Wise Engineering
3915 Old Fairground Rd.
Angier, NC 27501
(919)894-2203

October 25, 2024

Subject: 5131 NC-55, Erwin, NC 28339

FOUNDATION STRUCTURAL PLAN

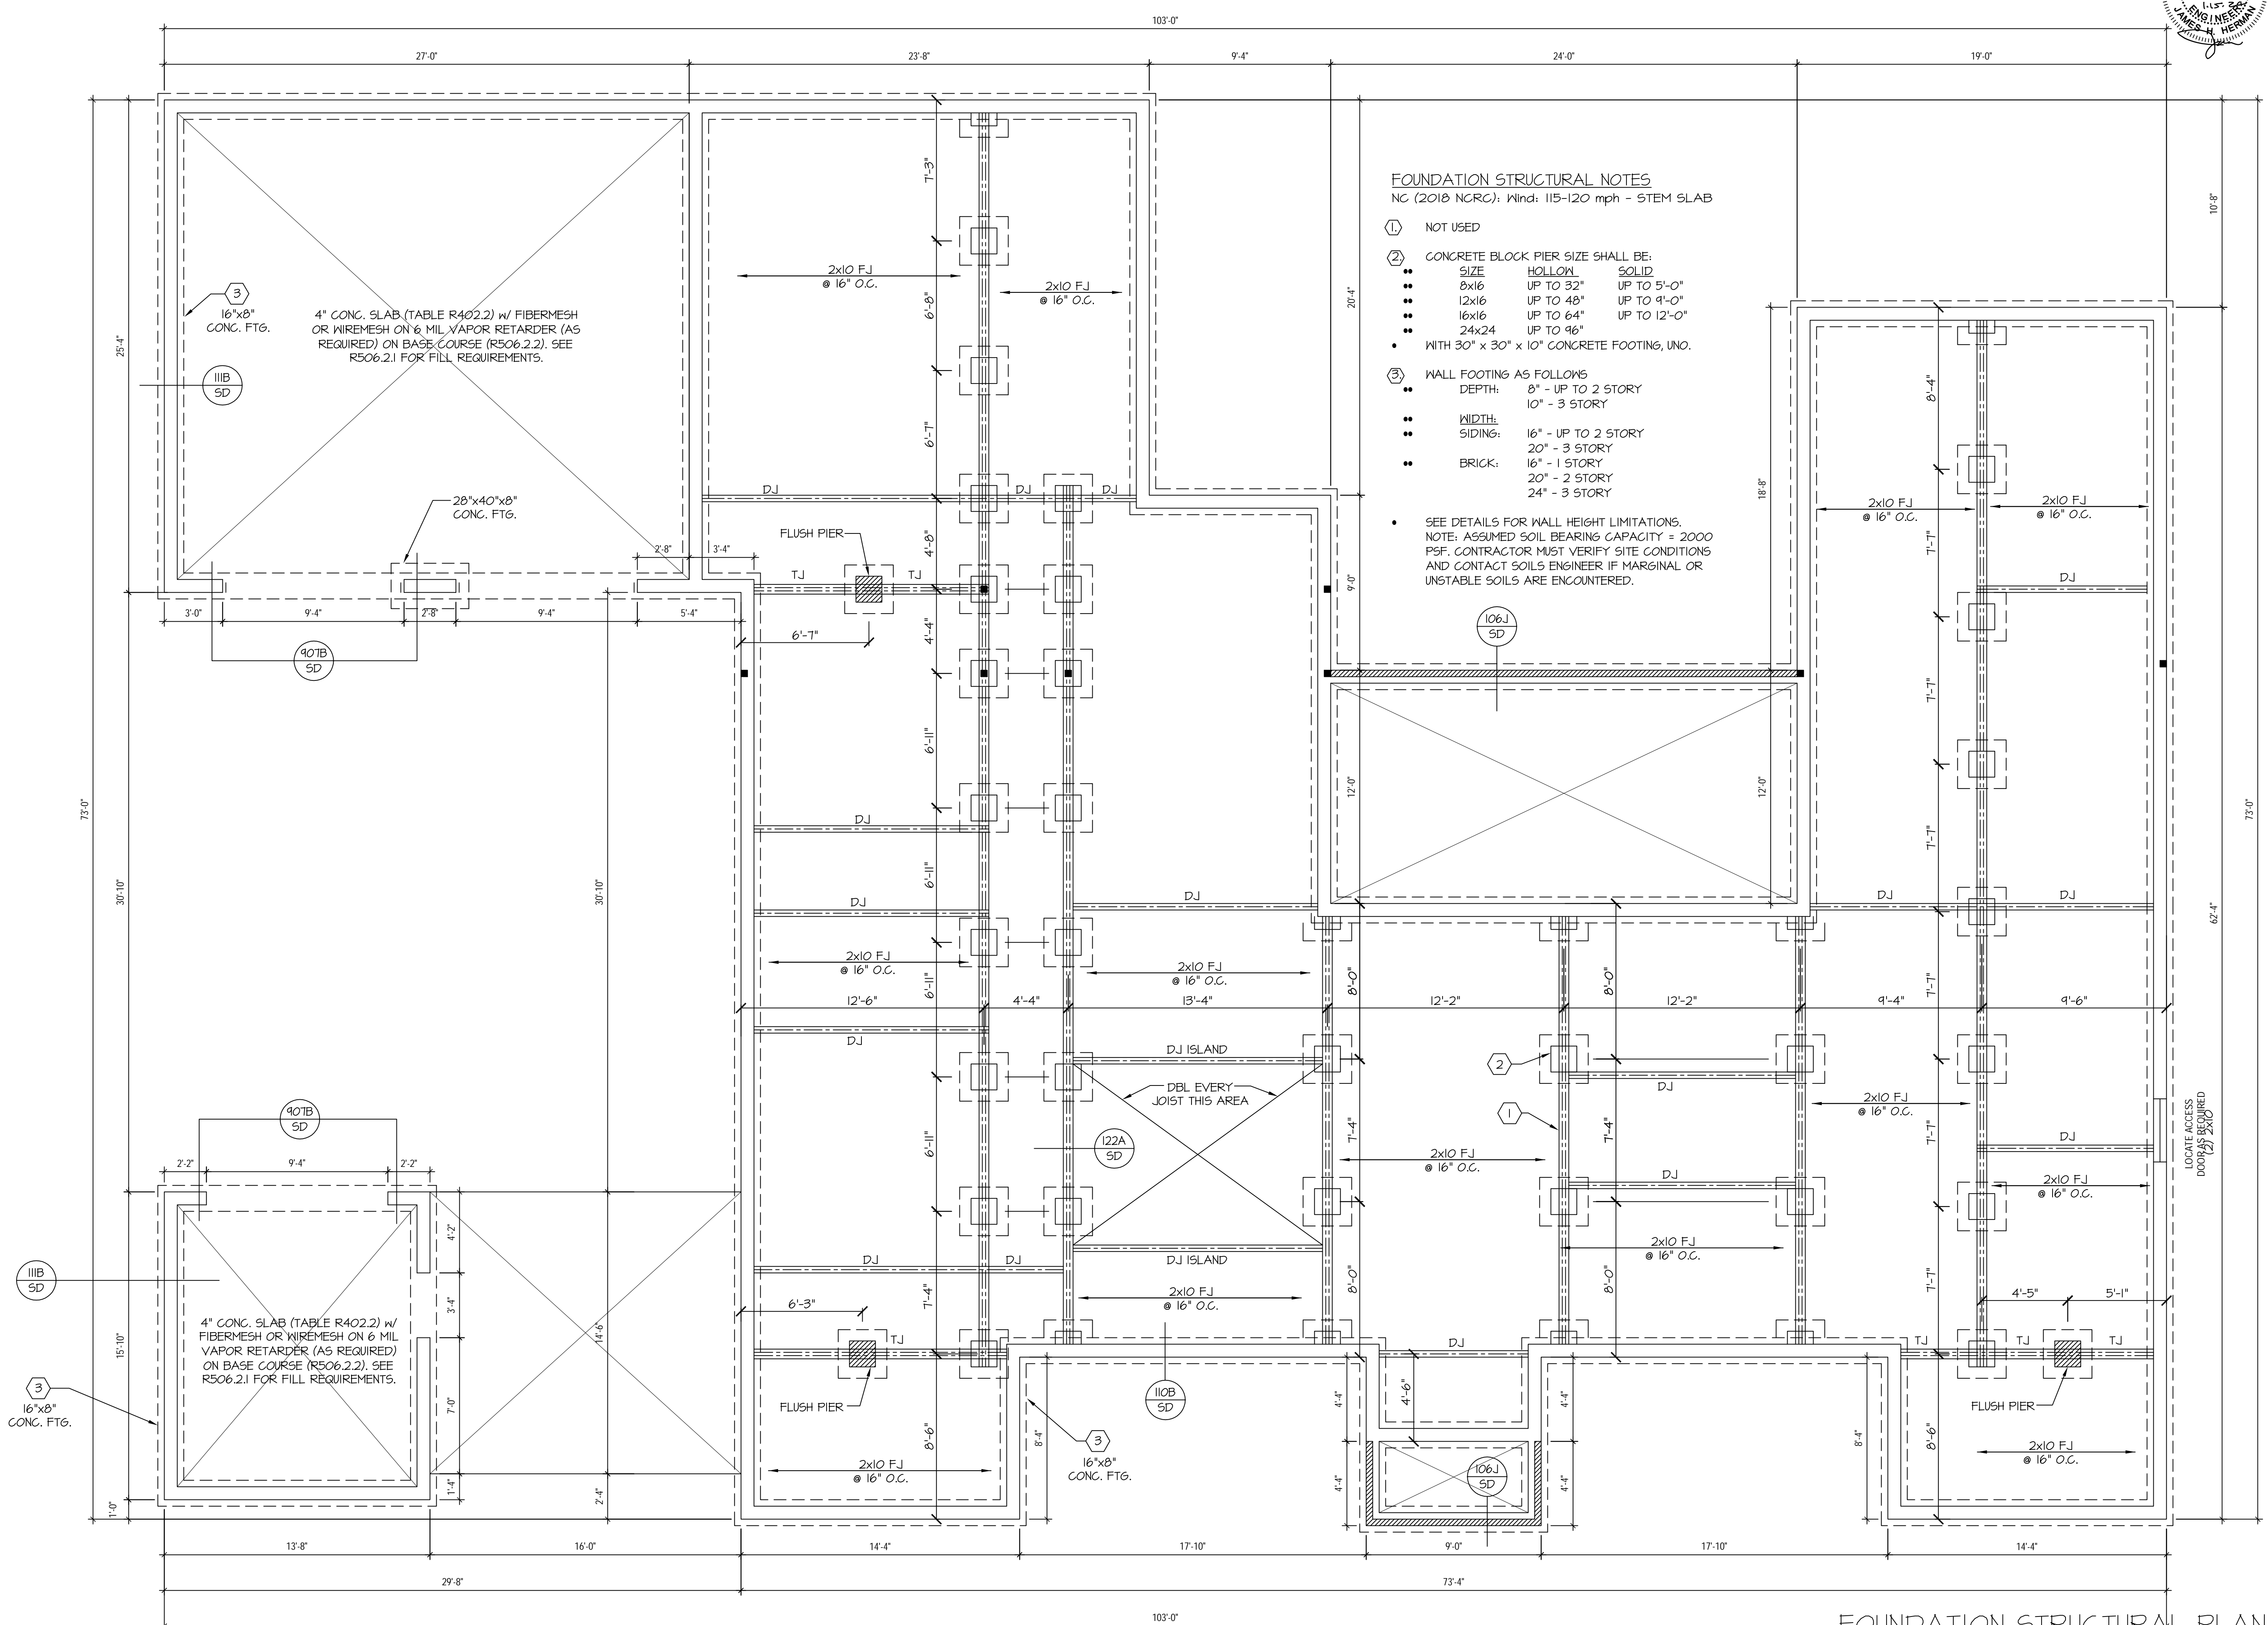
A representative from Wise Engineering (WE) was on-site to observe the existing footing excavations located at 5131 NC-55, Erwin, NC 28339 and to test the bearing capacity of the existing soil within the footings.

Based on our observations and the results of our field tests, the footing excavations were over excavated in one area by approximately 1'-6" and backfilled with clean washed #57 stone. The footing excavations are structurally adequate as constructed to support the anticipated loading conditions (2000 PSF bearing capacity). A representative from WE made an additional site visit and there was water present in the footing excavations. The water within the footing excavations should be pumped out prior to concrete placement.
